Our Ref: Y/12/21/NMA

Non-material amendment following grant of Y/103/18/PL (W/4000394) for minor alterations to building layouts and elevations

10 acre Field Land north of Grevatts Lane Bilsham Bognor

DRAWING TITLE
GA Plan - Level 00

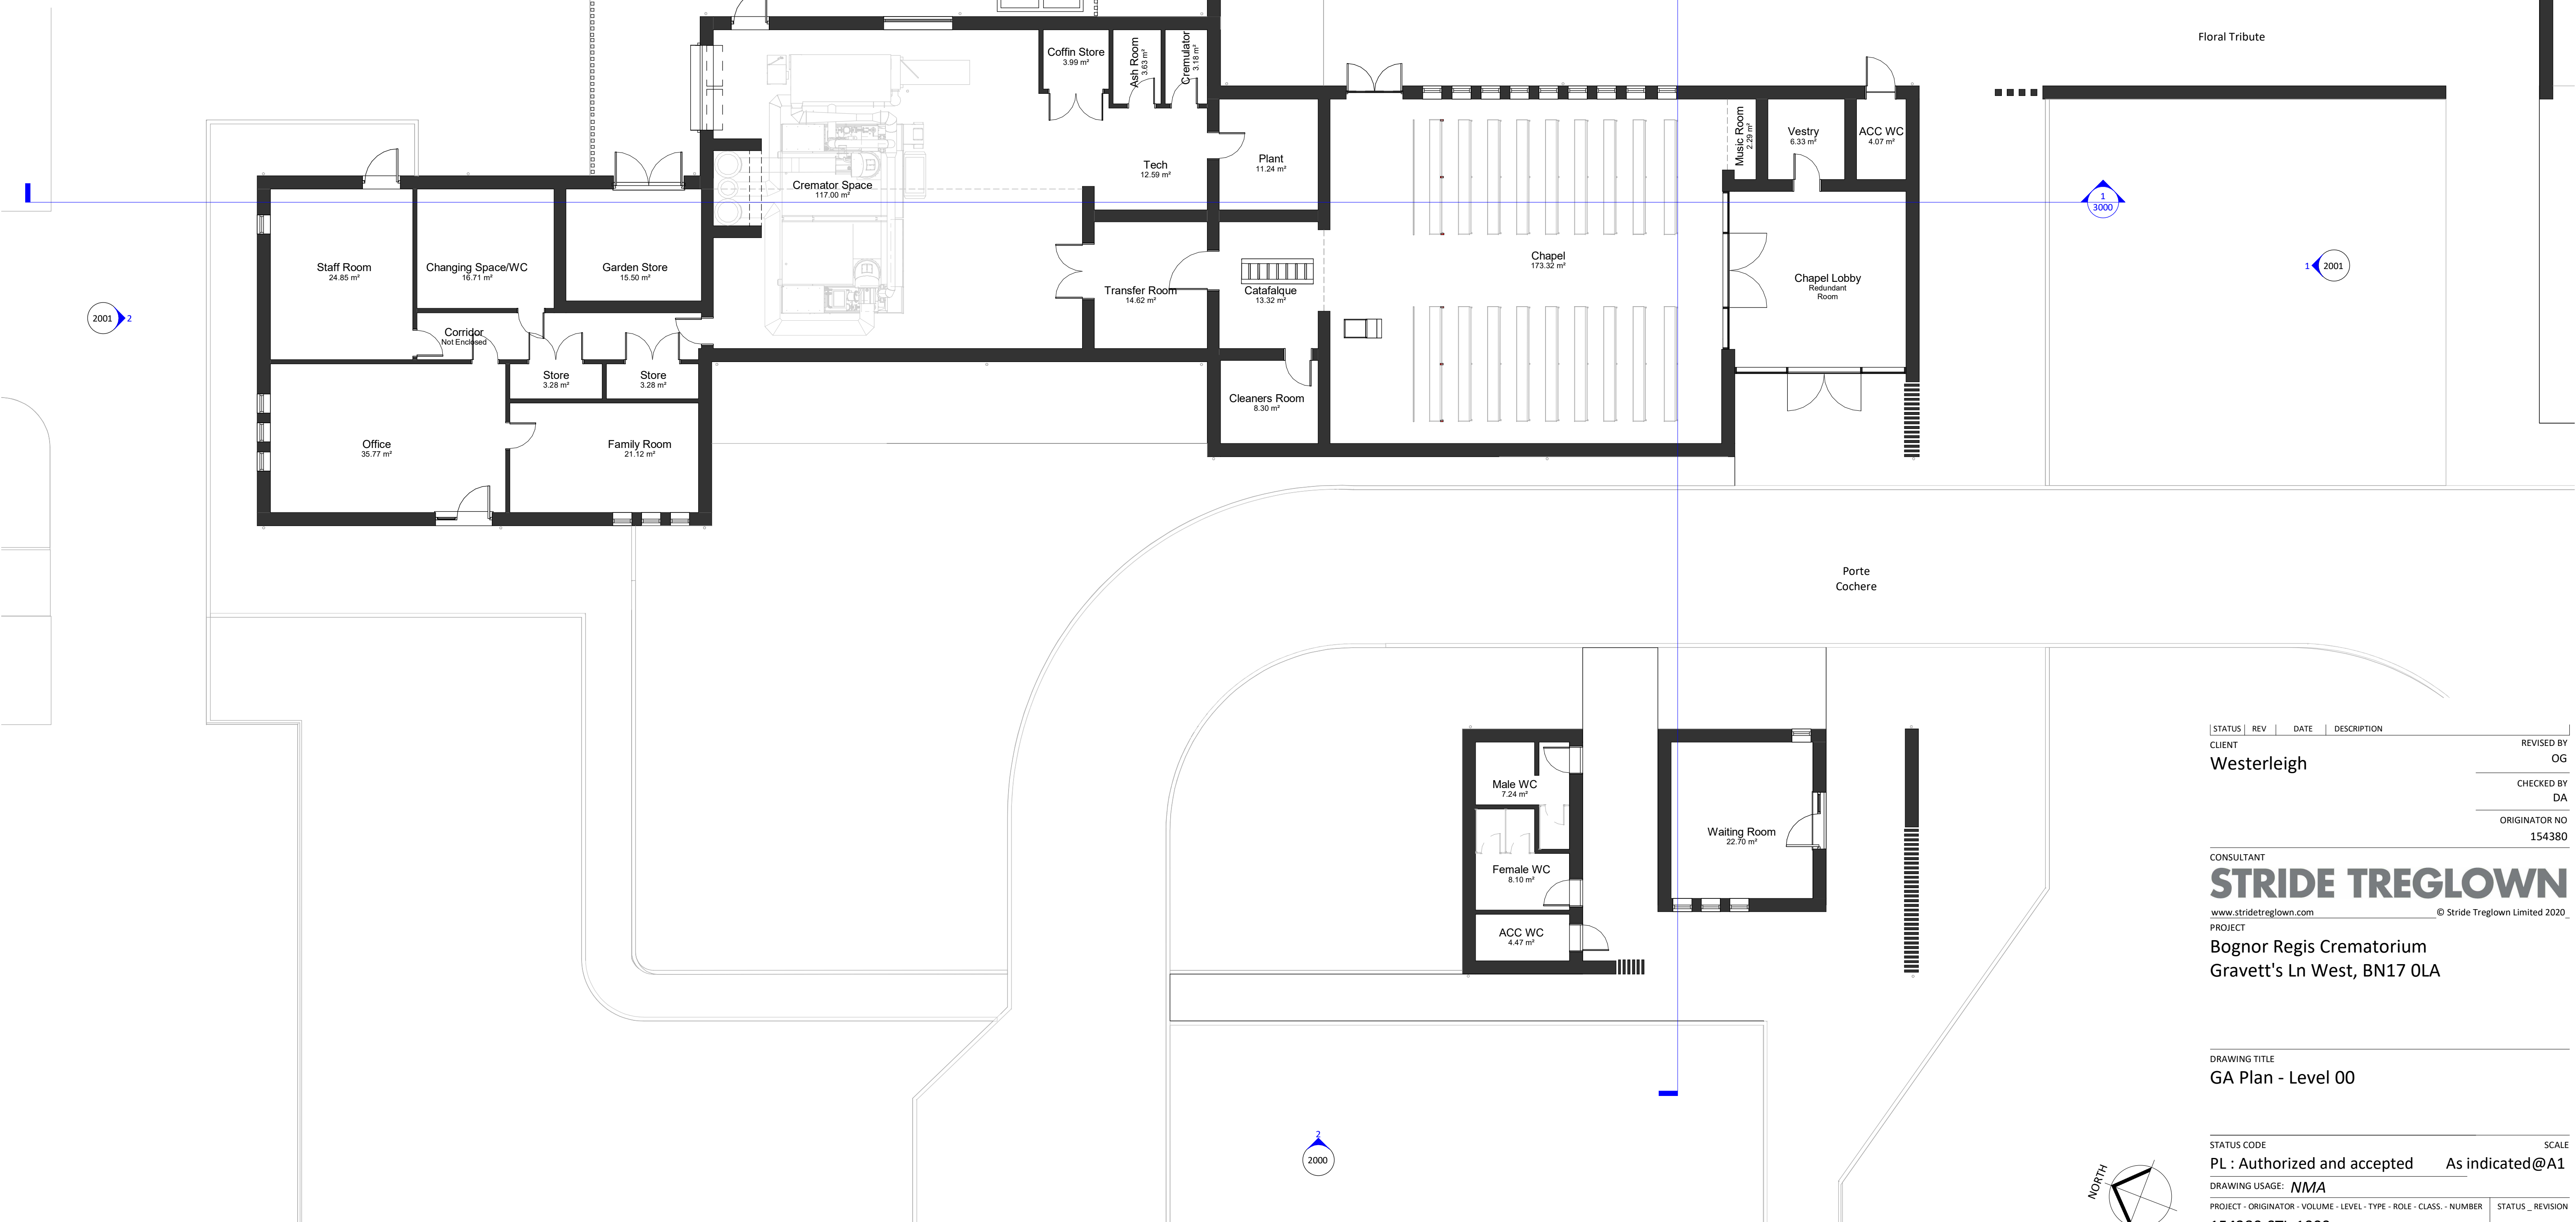
I refer to your recent application for a Non Material Minor Amendment. I note that you propose to make some minor alterations to the size, footprint and design of the approved building as shown on the accompanying drawings but with an overall reduction in its size (the floorspace reduces by 51.48sqm to 578.33sqm).

It is considered that the proposed changes will not materially alter the appearance of the development approved by the planning permission, do not conflict with any conditions of the permission, do not breach any planning policy, do not warrant re-consultation and are within the maximum dimension change tolerances. Whilst the scheme does slightly reduce the amount of parking spaces, it is noted

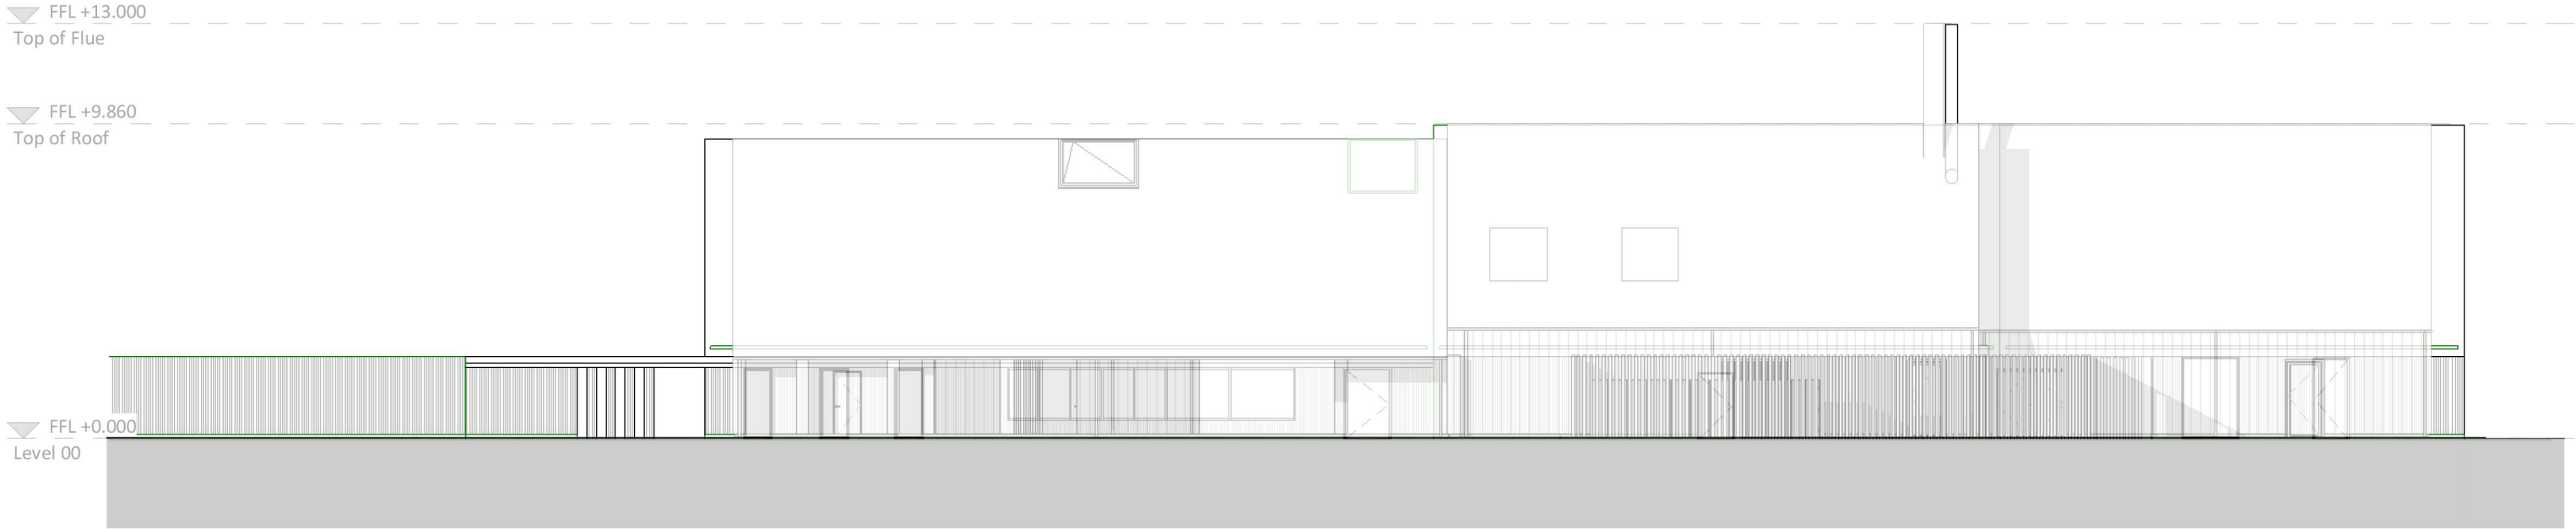
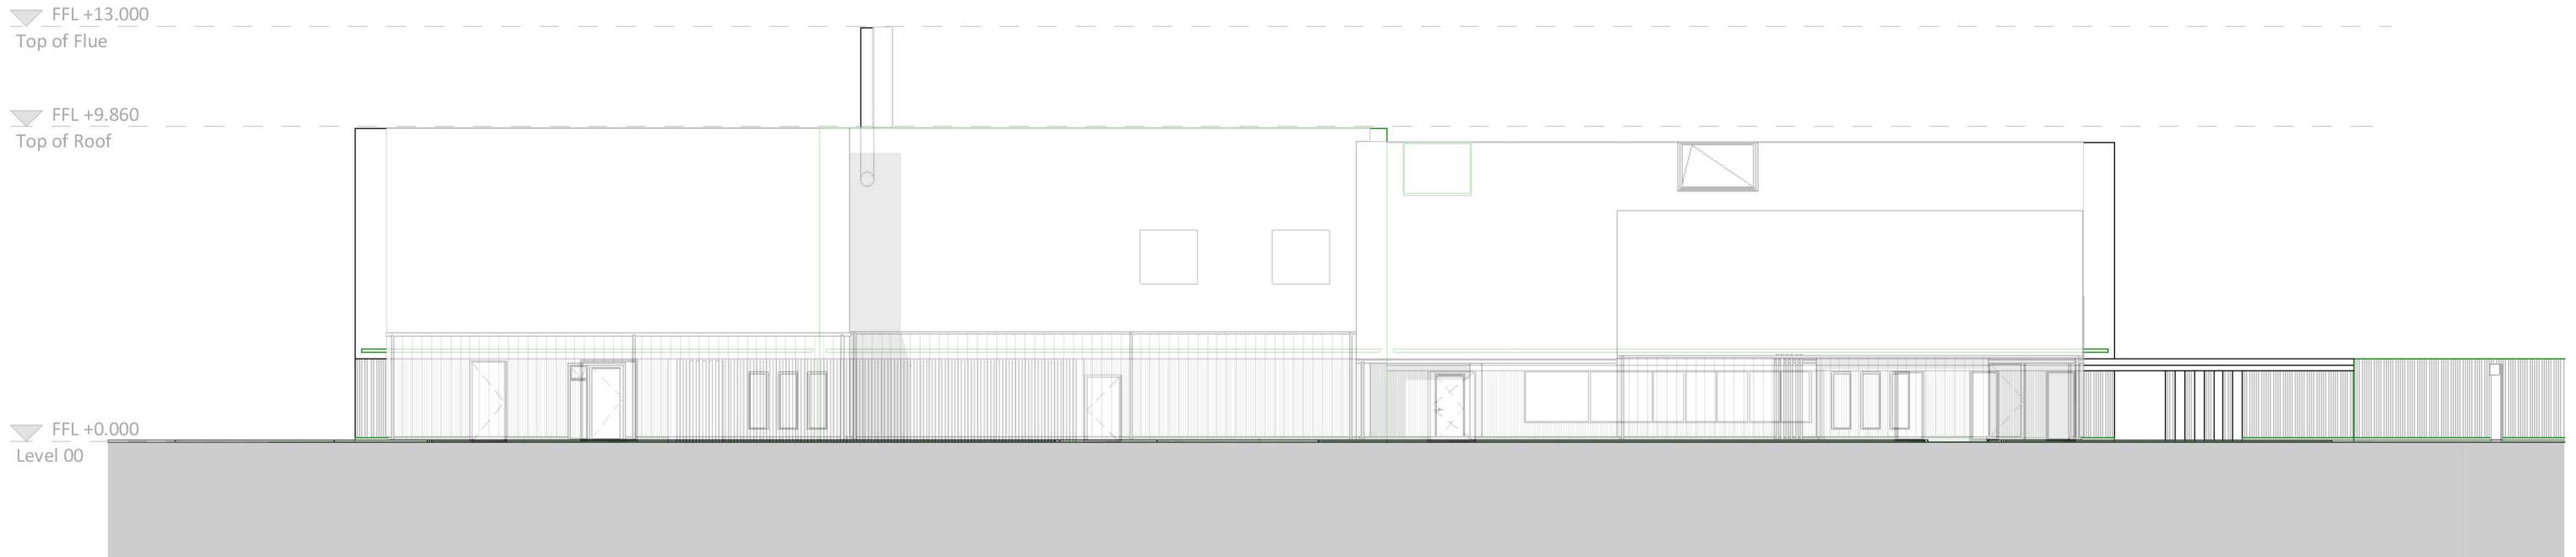
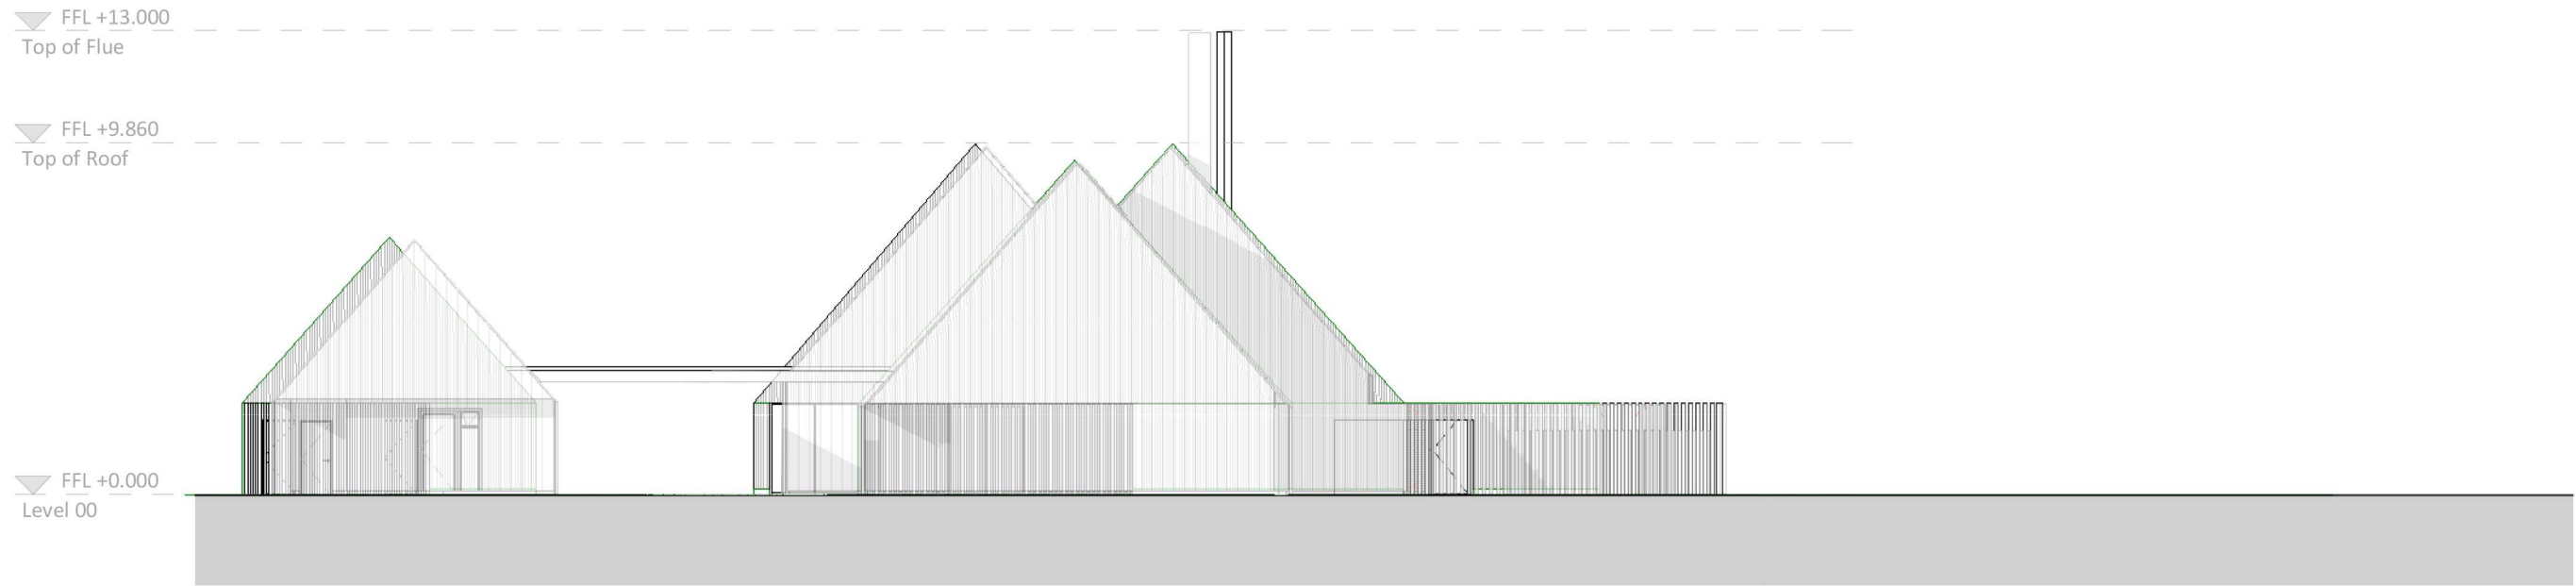
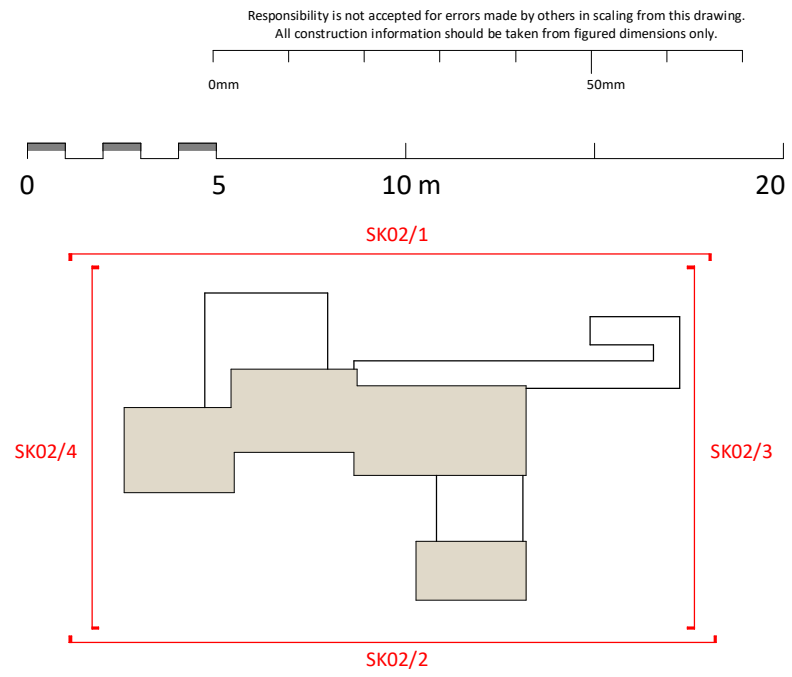
There are no changes to the overall height or bulk of the roofs and the footprint moves by less than 1m. I also note an enlargement of the rear external storage area and changes to the parking layout (with 2 less parking spaces than before) and changes to internal site roads/paths and landscaping.
